We have the following comments regarding this application to discharge drainage conditions.

Condition 6 – Surface Water Drainage Design

Application No: BN/57/20/DOC
Registered: 3rd June 2020
Site Address: Land Rear of Lillies Yapton Road Barnham PO22 0AY
Description of Works: Approval of details reserved by condition imposed under ref BN/32/15/OUT relating to Condition Nos 6 - surface water drainage, 7 - discharge flows, 8 - SudS, 9 - future access & maintenance of any watercourse and 10 - surface water drainage

REV	DESCRIPTION	DRN	CHD	DATE
☐ PRELIMINARY	☐ INFORMATION	☐ TENDER		
☐ CONSTRUCTION	☐ AS BUILT			
SCALE	N.T.S @ A1	DATE	APRIL 2020	
DRAWN	SD	CHK	JGF	
DRAWING NO.	17748-BARN-5-921	REV	-	
TITLE	YAPTON ROAD BARNHAM			
DETAILS	PRIVATE PERMEABLE PAVING CONSTRUCTION DETAILS

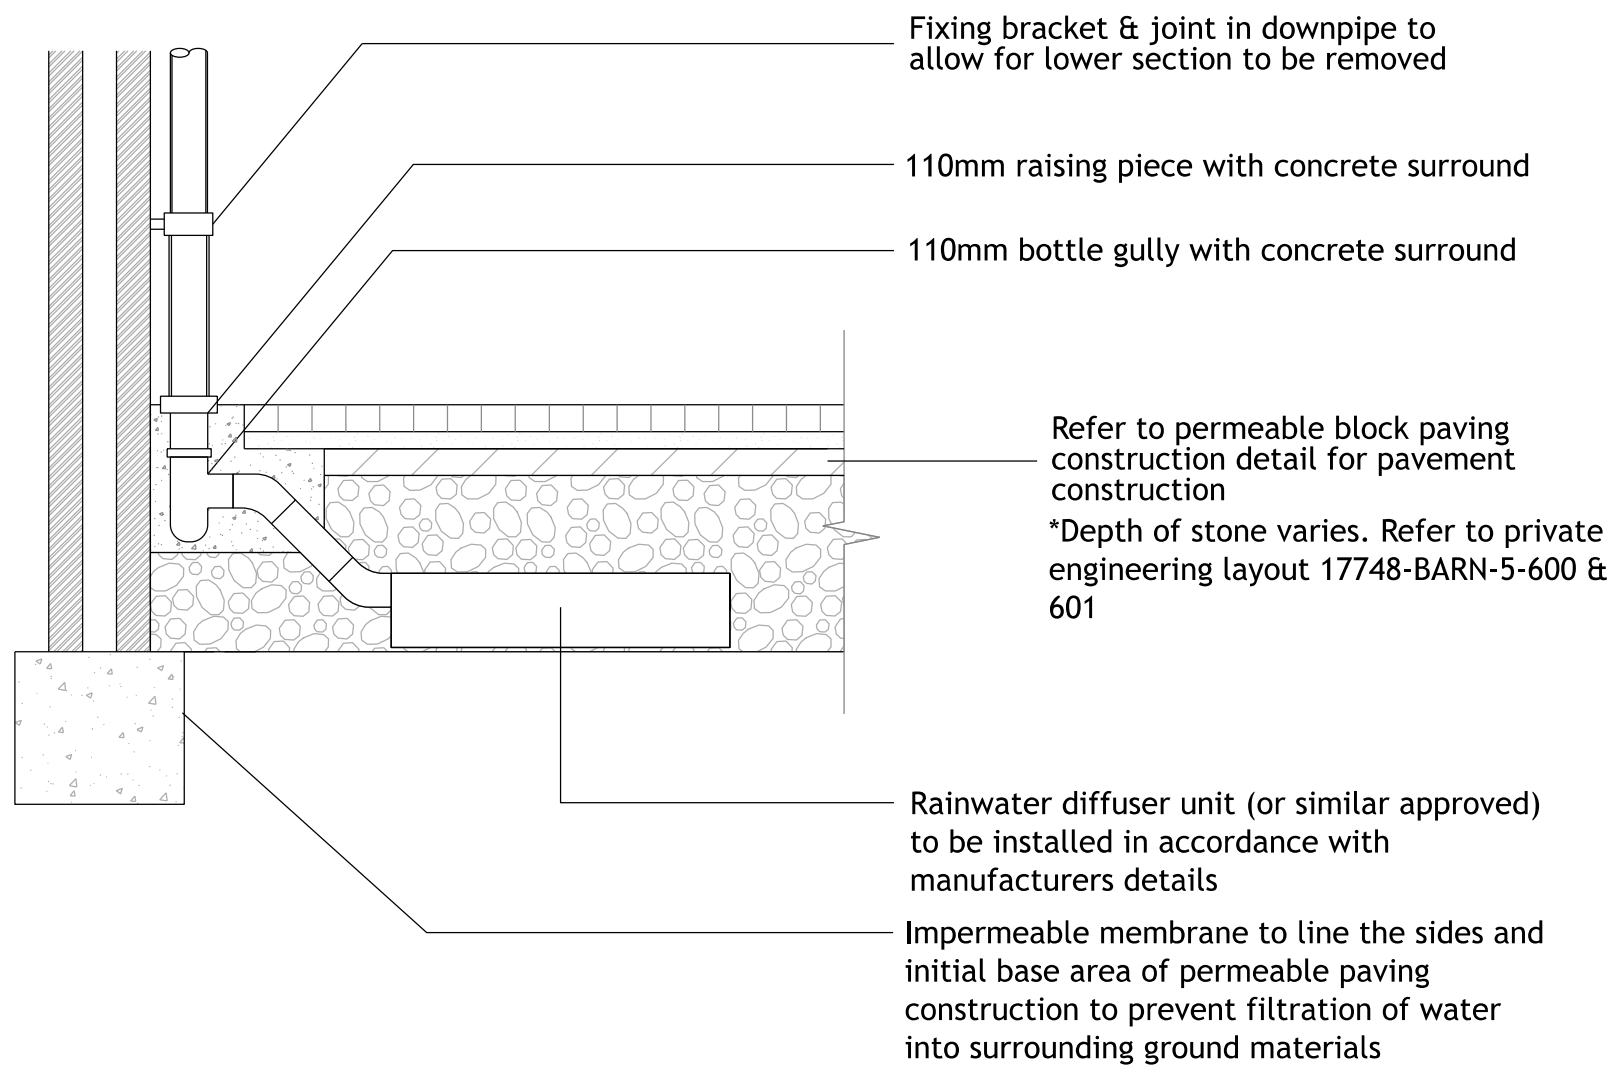
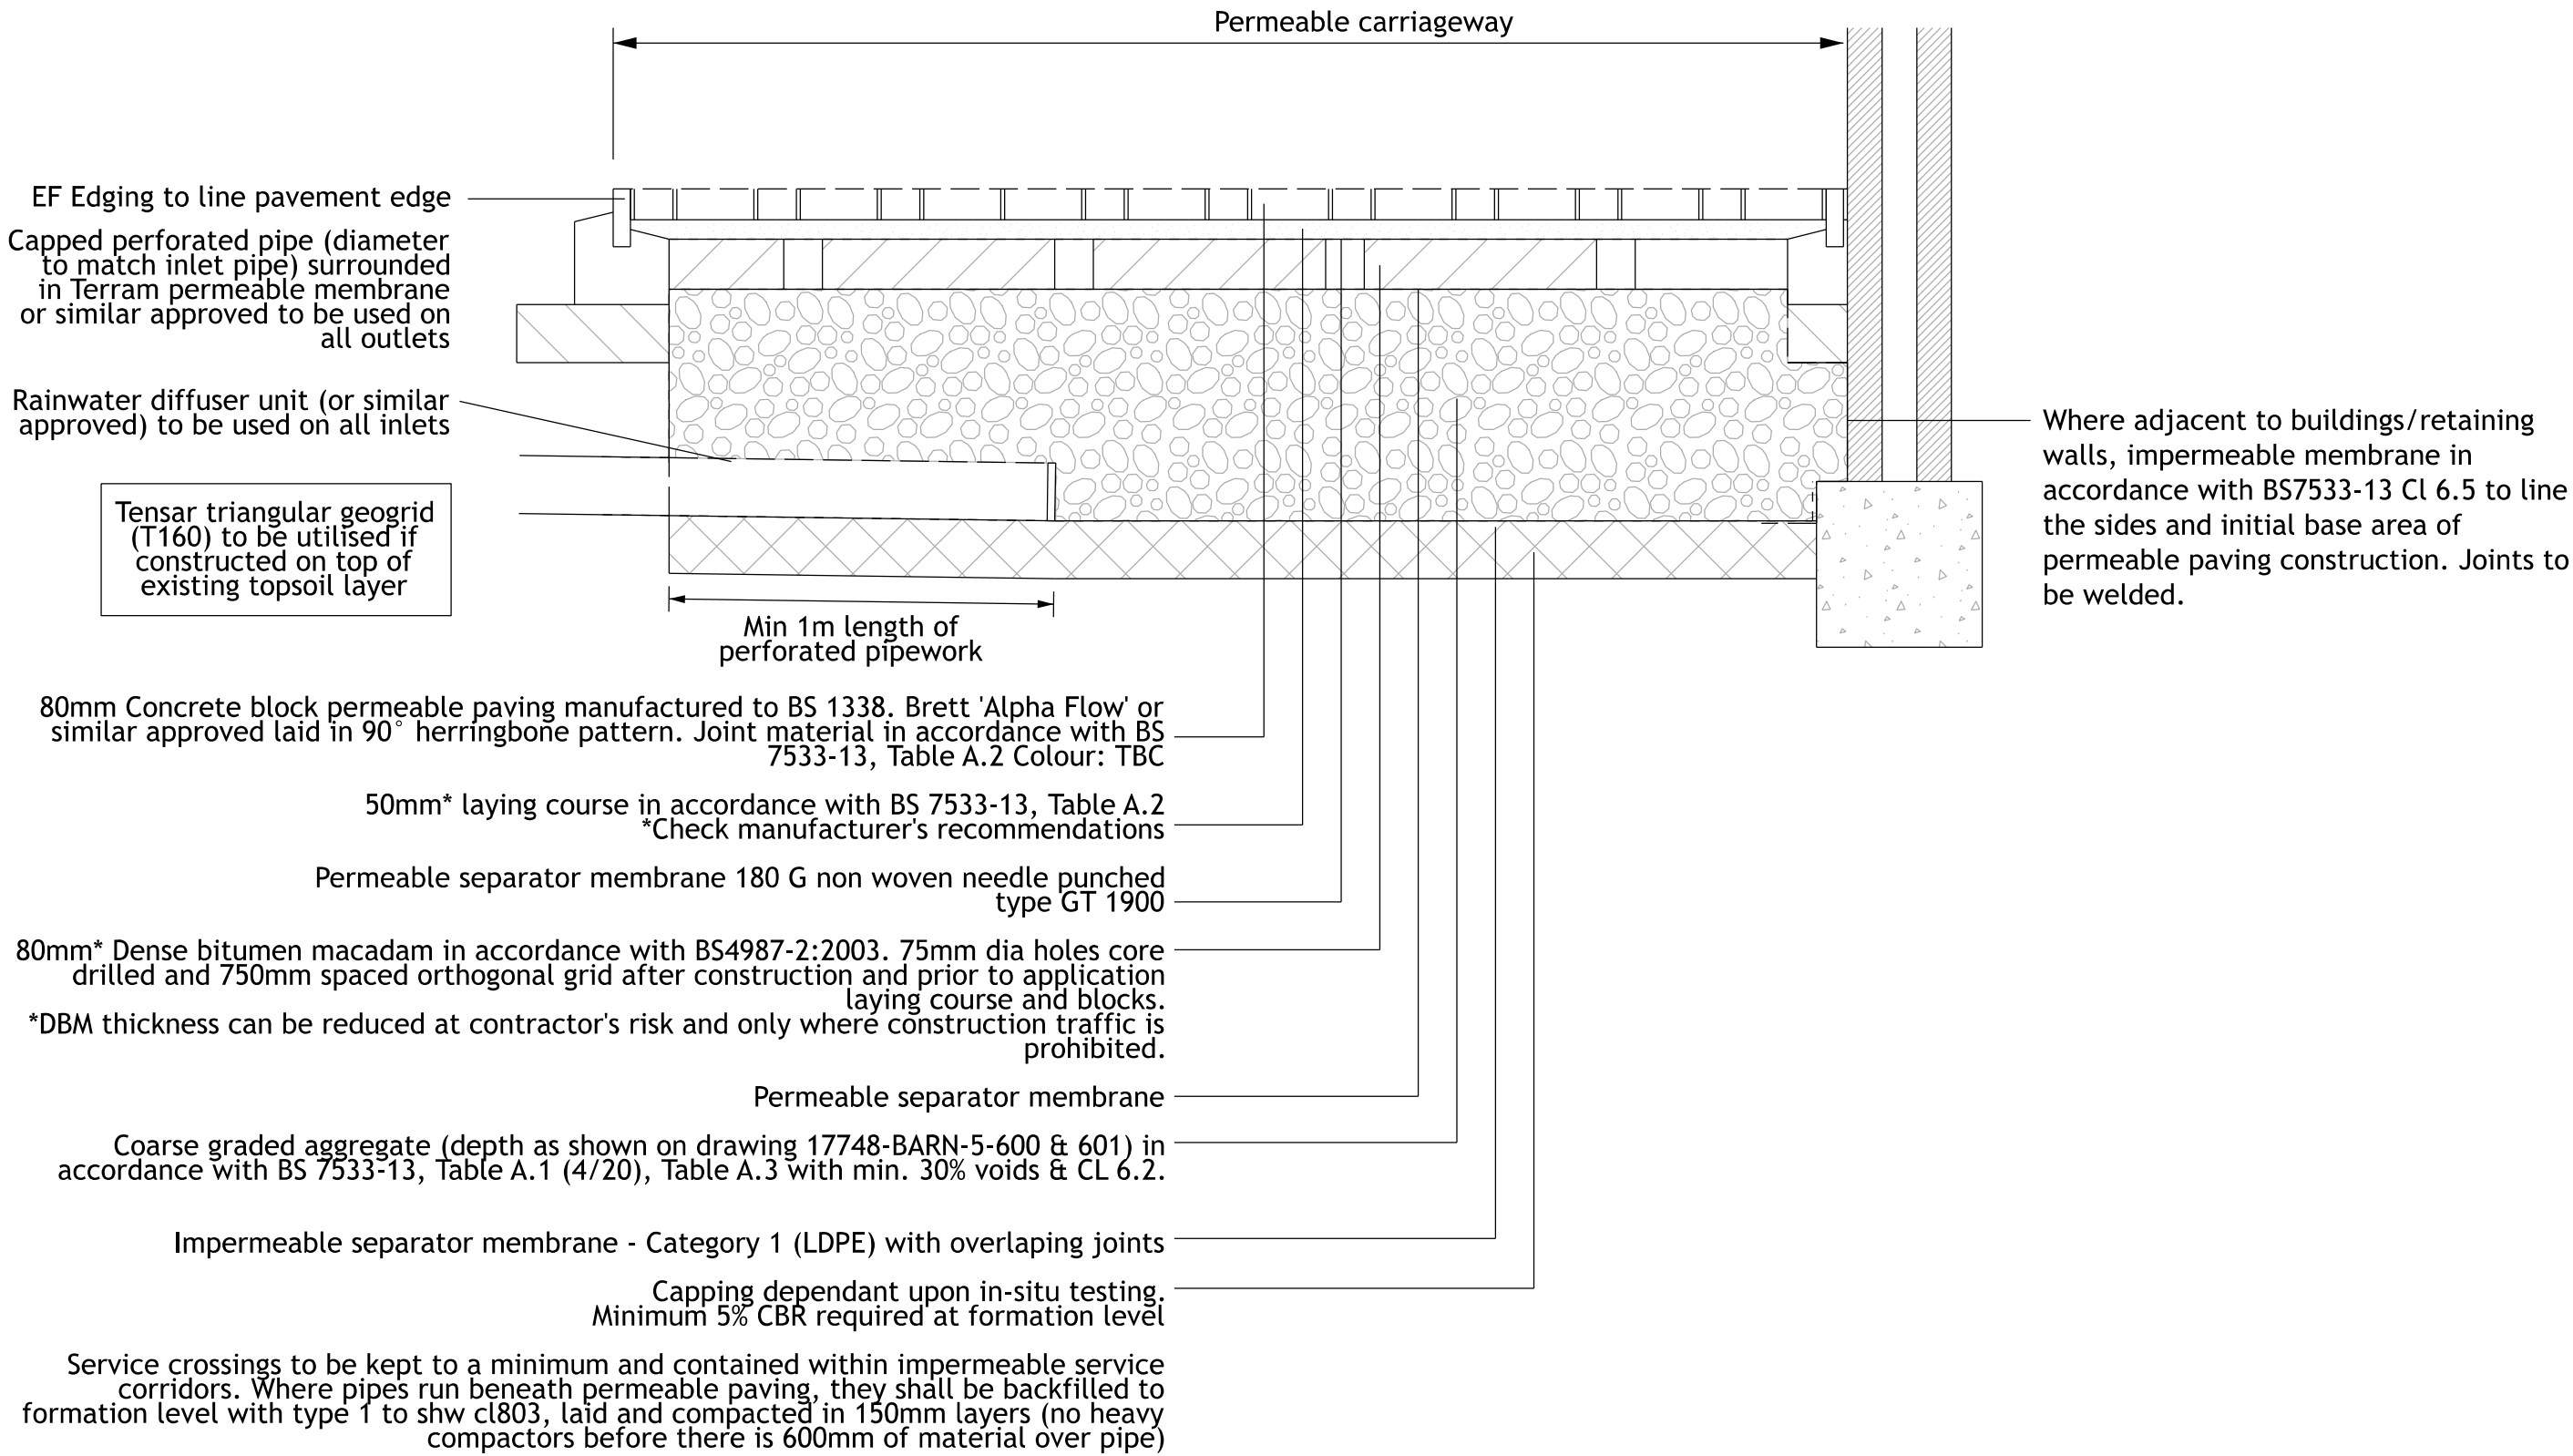
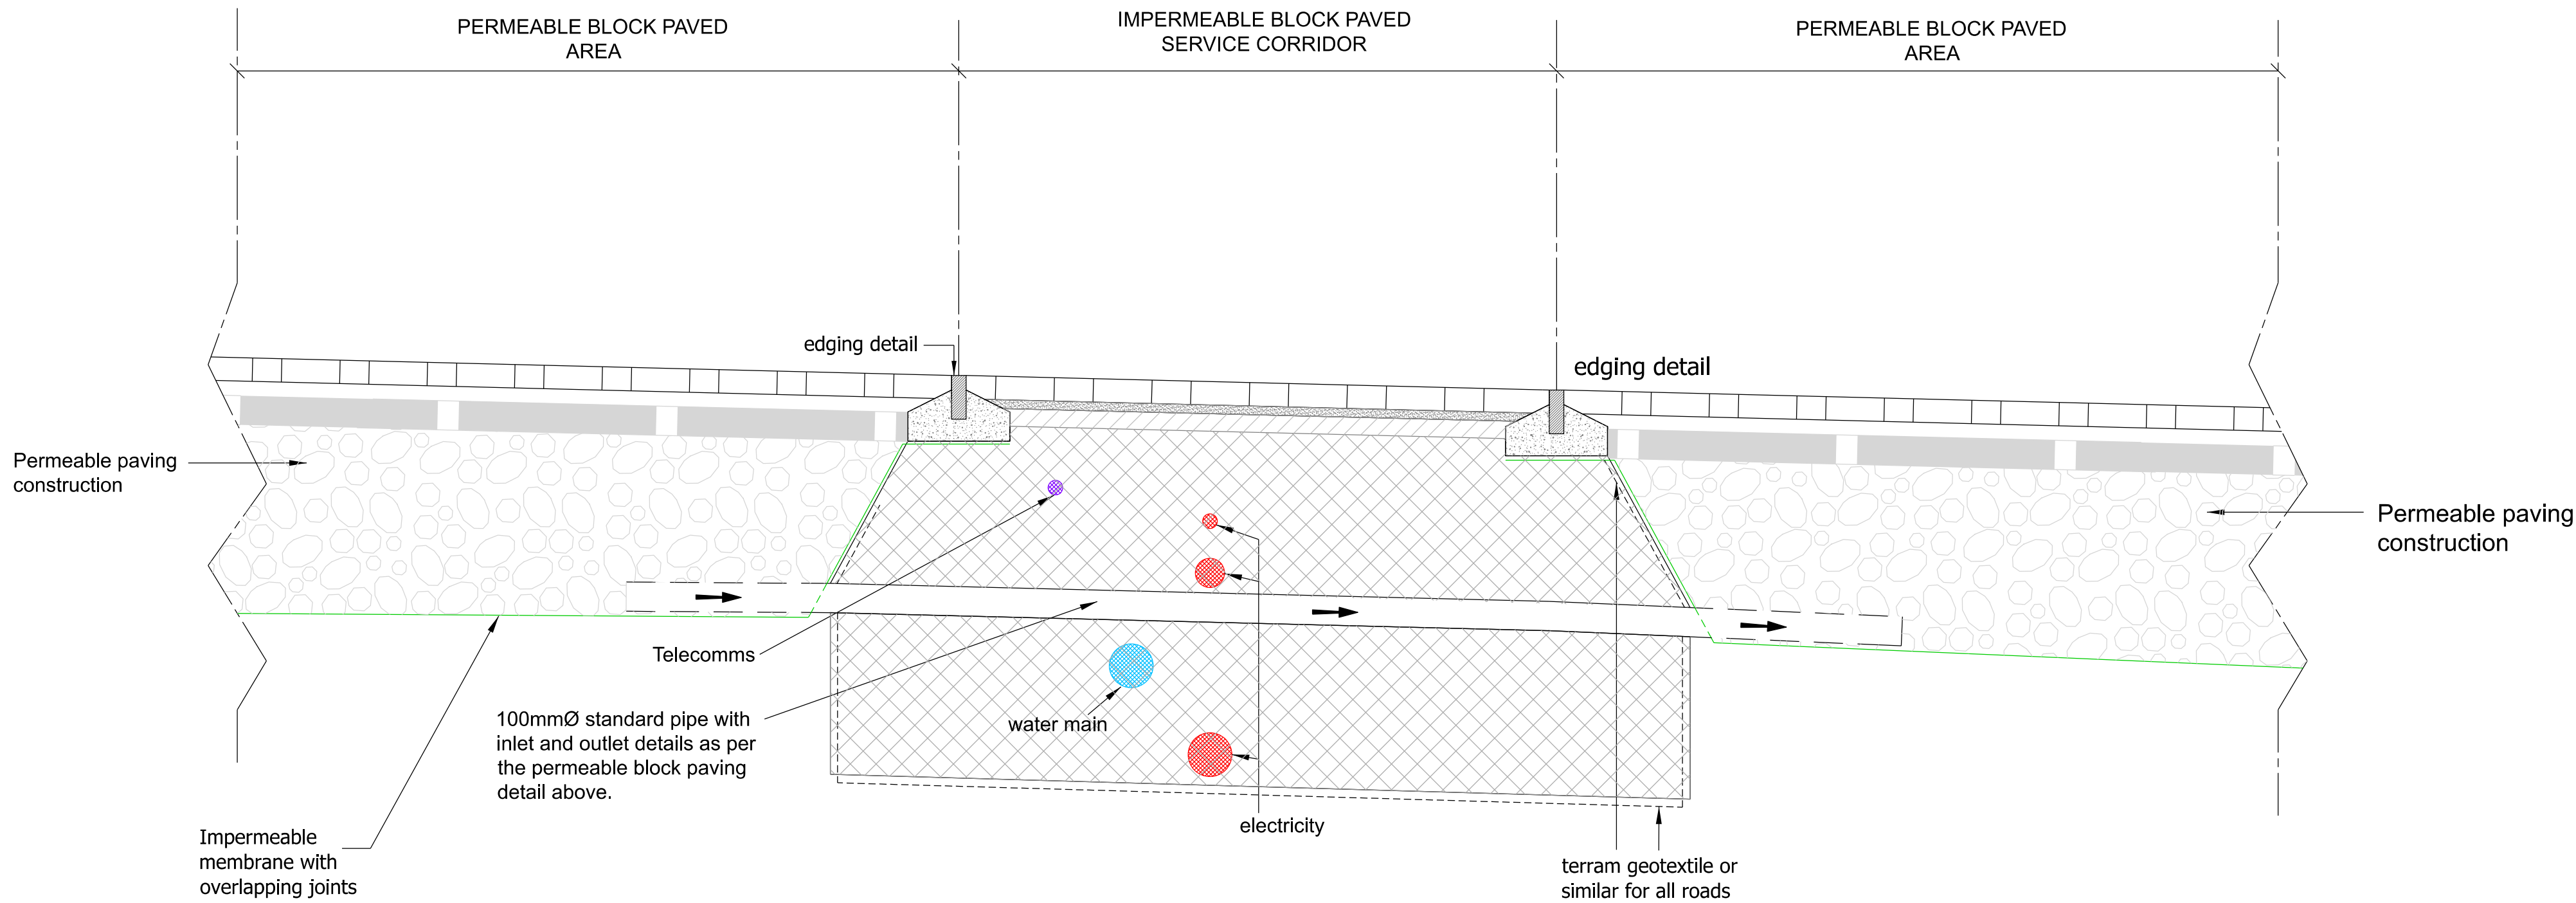
15. Detail how water will flow between sub-base either side of service corridor construction for foul sewer.
16. Please include a manhole schedule.
17. Please detail how ACO drain near hydrobrake connects, this is not clear.

19. Cranked grille must be provided.
20. Please provide further detail of granular material proposed for filter drain. Please indicate ditch invert level at proposed point of connection to watercourse.
21. Please provide construction detail drawings of orifice control chambers. Including detail of blockage protection.
22. Permeable paving construction detail drawing required.

1 : 10 ACO CivicDrain Pavement (Option 1 and 2)

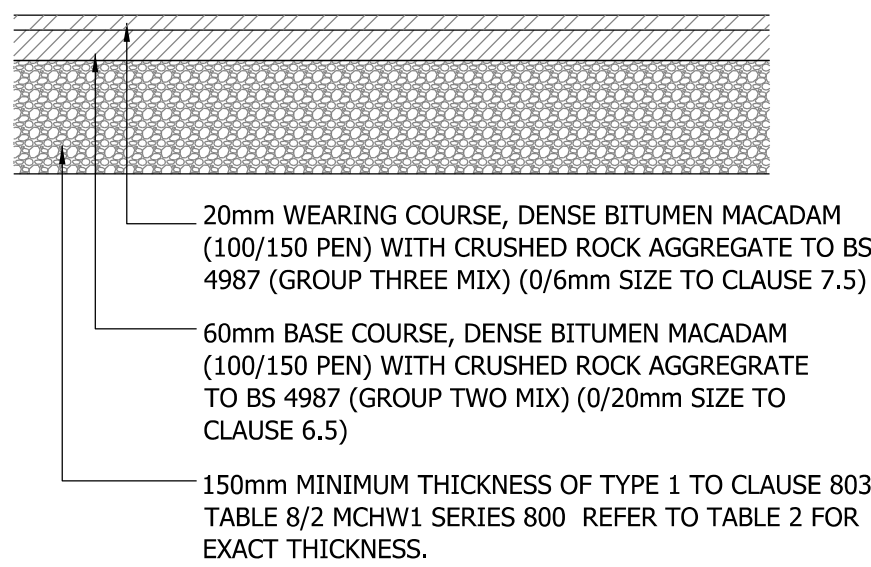
18. Please provide further detail on ACO drain, i.e. bedding, silt trap, etc.
